Re: New Office/ Ware House
541 Airport Dr. NW
Conceptual Traffic Circulation Layout for DRB Approval
Architect's Stamp 07-12-22 (K10-D023K)

**Re: NEW OFFICE/WAREHOUSE
541 Airport Drive NW
Traffic Circulation Layout
Architect's Stamp None (K10-D023)**

Subject-New Office/Warehouse- 541 Airport Drive NW
Traffic Circulation Layout Review

4 ACCESSIBLE PARKING
1/8"=1'-0"

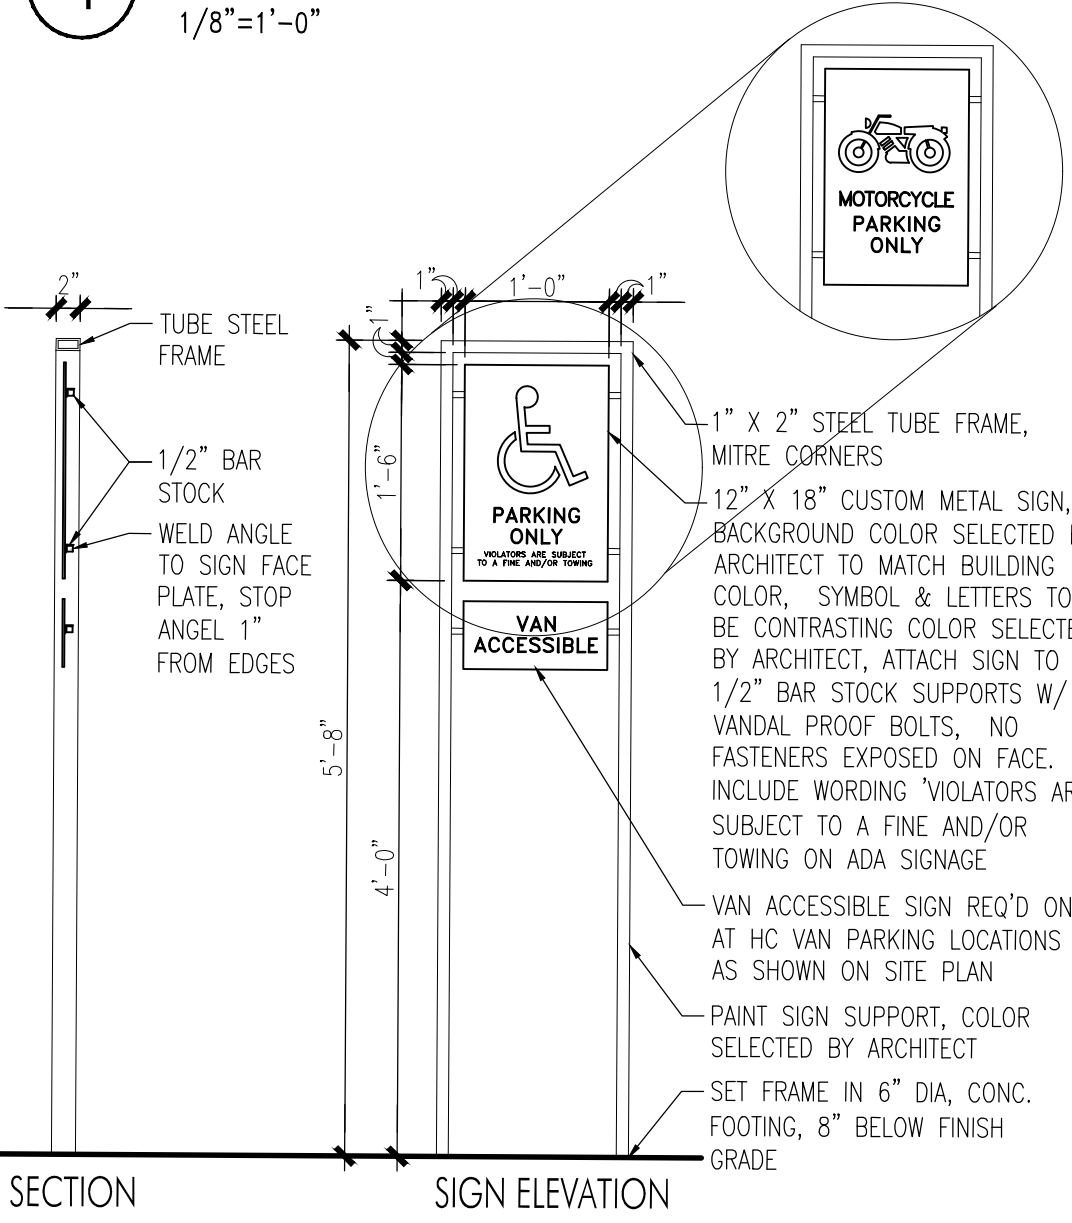
9. **Detail 4 (Accessible Parking):**
 - **The landing will need to be label 50:1 max in all directions.**

- **NO PARKING:** Detail for the text will need to be provided.

15. The ADA access aisles shall have the words **"NO PARKING"** in capital letters, each of which shall be at least one foot high and at least two inches wide, placed at the rear of the parking space so as to be close to where an adjacent vehicle's rear tire would be placed. (66-1-4.1.B NMSA 1978). **Provide details.**

9. Refer to revised details for HC parking.
10. Refer to revised drawings for clarifications doors, sidewalks etc.
11. Refer to revised drawings for easement and ROW clarifications.

15. Refer to revised ADA access aisle details.
16. Refer to revised plans for truncated domes at new curb ramps and the existing curb ramp at intersection.

3 PARKING SIGNS
3/4"=1'-0"

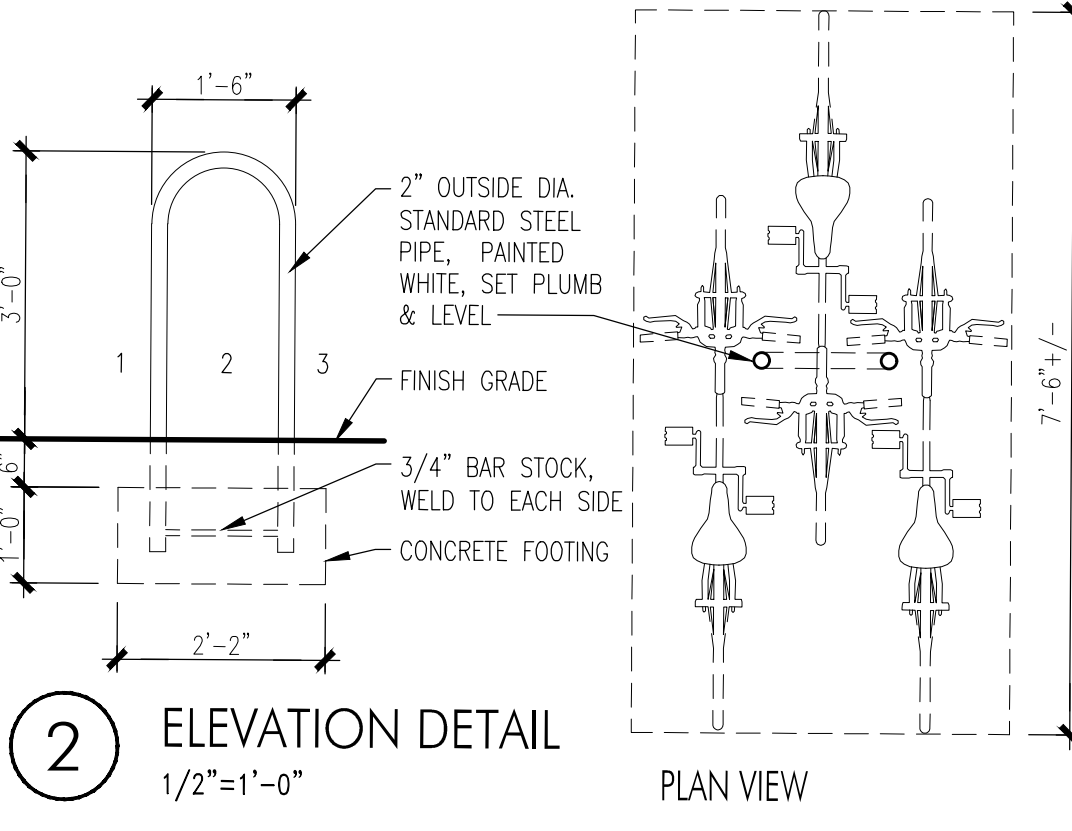
14. The ADA accessible parking sign must have the required language per 66-7-352.4C NMSA 1978 **"Violators Are Subject to a Fine and/or Towing."** Please call out detail and location of signs. The sign height is not correct. **Please review COA standards for correct signage height.**

12. Refer to revised plans.
13. Refer to revised motorcycle parking details for stall dimensions.
14. Refer to revised HC parking sign details for added notes.

SDP-1

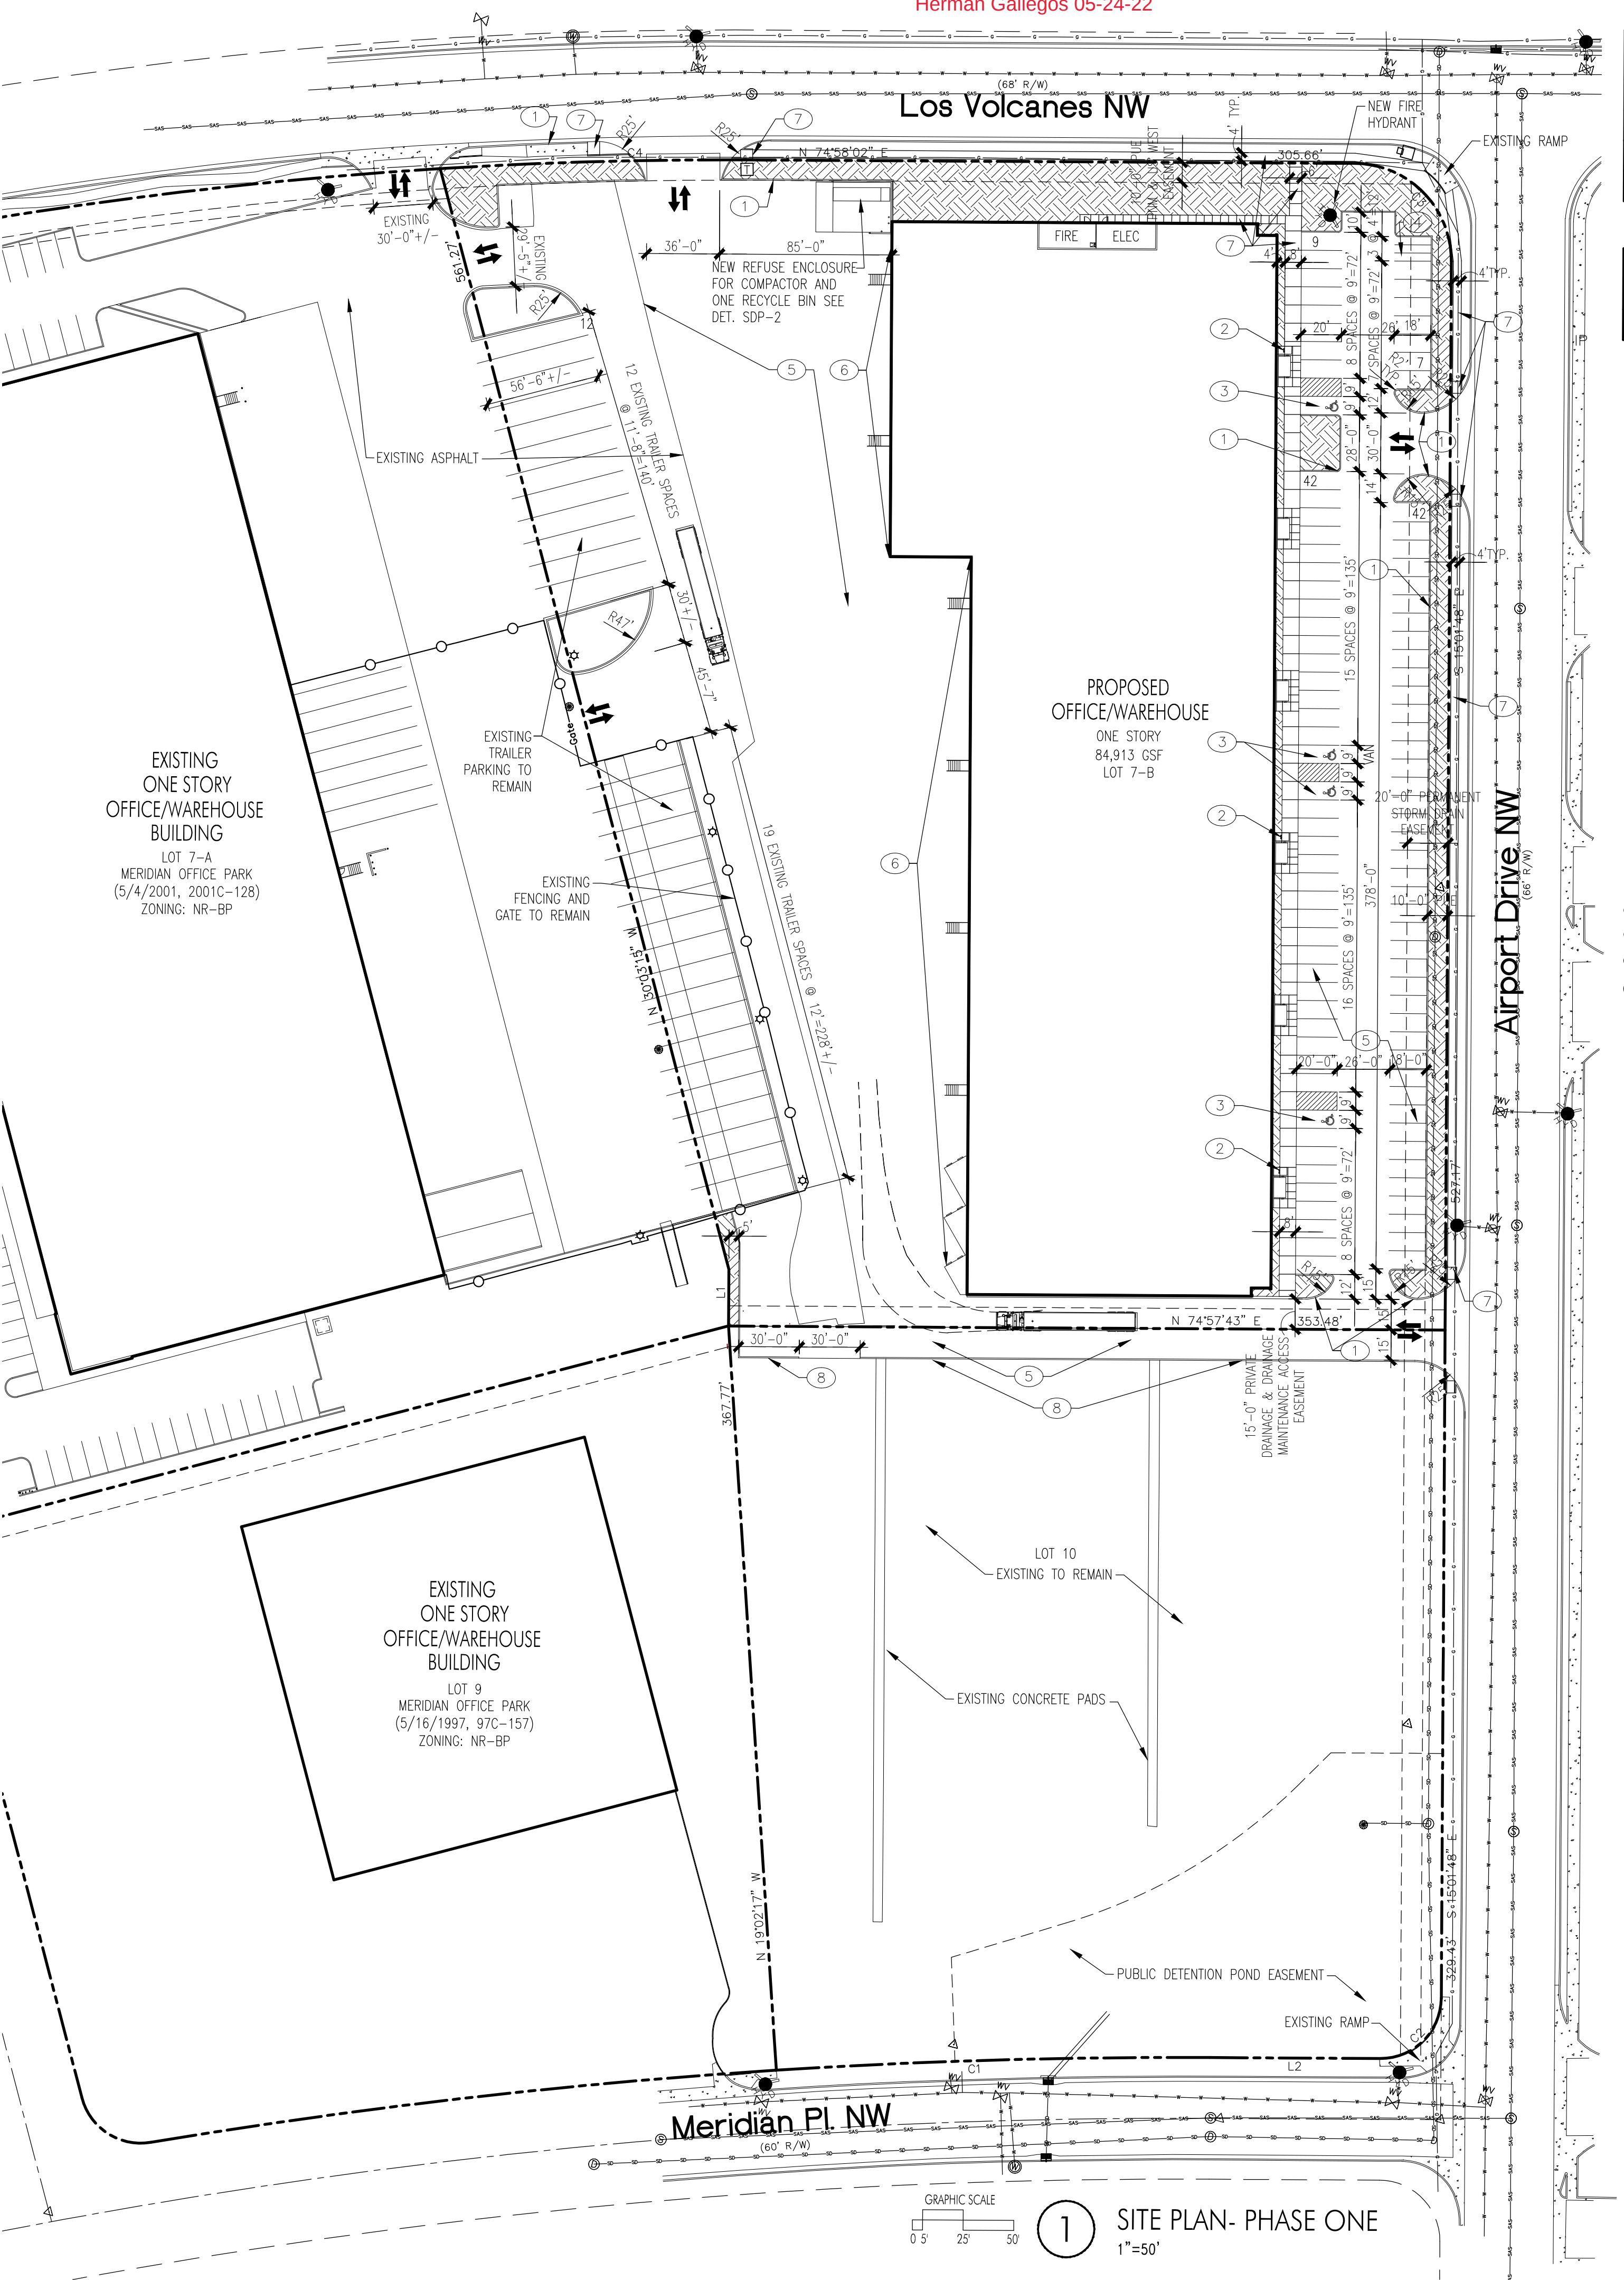
2. Clarify the extents of the current phase 1 versus phase 2. Are you proposing phase 2 as part of this submittal ? Explain since phase 2 is on a different lot and will required a separate submittal and fees. I will not comment on sheet SDP-2 until the appropriate action is taken for the submittal process.

3. The traffic circulation layout must be stamped, signed, and dated by an engineer or architect licensed in the state of New Mexico.
4. **Proposed Driveway (Los Volcanes):** Provide entrance design or reference design per COA std dwg 2426.

5. **Airport Driveway:**
 - **First proposed drive entrance location:** What is the distance from Los Volcanes? Verify you meet the required distance from a Collector on Airport.

- **Second proposed driveway:** How will you provide a 6 ft valley gutter across the 30 ft driveway when you are only providing temp. extruded curb and status of ramp on the southside of entrance.

6. **Keyed Note 1:** Please reference detail and sheet number.
7. **Keyed Note 7:**
 - Please provide entrance ramp detail since a detail has not been provided.

- Sidewalk detail will be needed and reference COA std dwg 2430 (public sidewalk) on both Los Volcanes and Airport Drive (when applicable).
8. **Keyed Note 8:** Need to provide detail.

10. Please identify all **proposed buildings, doors, structures, sidewalks**, curbs, drive pads, wall and anything that influences the parking and circulation on the site.
11. Identify all existing access easements and rights of way width dimensions.
12. Identify the right of way width, medians, curb cuts, and street widths on Los Volcanes and Airport Drive.
13. **The minimum parking stall dimensions are:**

16. All ADA curb ramps within public ROW must be updated to current standards and have truncated domes installed. Please verify corner of Los Volcanes/Airport ramp complies with these requirements stated.

24. All proposed pavement markings and striping will need details.
 25. Parking areas shall have barriers to prevent vehicles from extending over sidewalk, and landscaping.

26. Corner of building will need bollards (details need and painted traffic yellow) so delivery truck will be aware and avoid any type of conflict.
 27. Provide a copy of refuse approval.

30. Please provide a sight distance exhibit
 31. **Intersection Sight Distance:** A clear sight line will be needed on Airport and Los Volcanes intersection for turning movements for Airport Drive.

32. Show the clear sight triangle and add the following note to the plan: "Landscaping and signage will not interfere with clear sight requirements. Therefore, signs, walls, trees, and shrubbery between 3 and 8 feet tall (as measured from the gutter pan) will not be acceptable in the clear sight triangle.

3. Revised plans have architect stamp, signed and dated.
4. Refer to revised plans for noted standard drawings at driveways.
5. Refer to revised plans for distance to drive and clarification on extent of the temp. extruded curb. Both Airport and Los Volcanes are collector streets.

6. Refer to revised plans for detail reference.
7. Refer to revised plans for std. dwg notes for ramps and sidewalks.
8. Refer to revised plans for temp. extruded curb detail.

23. Refer to plans for clarification. We have 8' wide sidewalks along the entire length of the building. We have hatched the conc. sidewalks to help clarify.

24. Refer to revised plans.
25. All parking areas have either conc. curbs or conc. parking bumpers.
26. Refer to revised plans for added bollards at corner.

27. Solid Waste approved plan is attached.
28. Approved Fire One plan is attached.
29. Refer to revised plans for paving design note.
30. Refer to revised plans for clear site triangles.

31. Refer to revised plans for site distances. See the legend for hatching.
32. Same as 30 above.
33. Refer to revised plans for added City Standard Drawing numbers.

Please refer to the revised SDP-1 and SDP-2 along with supporting documents. Let us know if you need any further clarification.
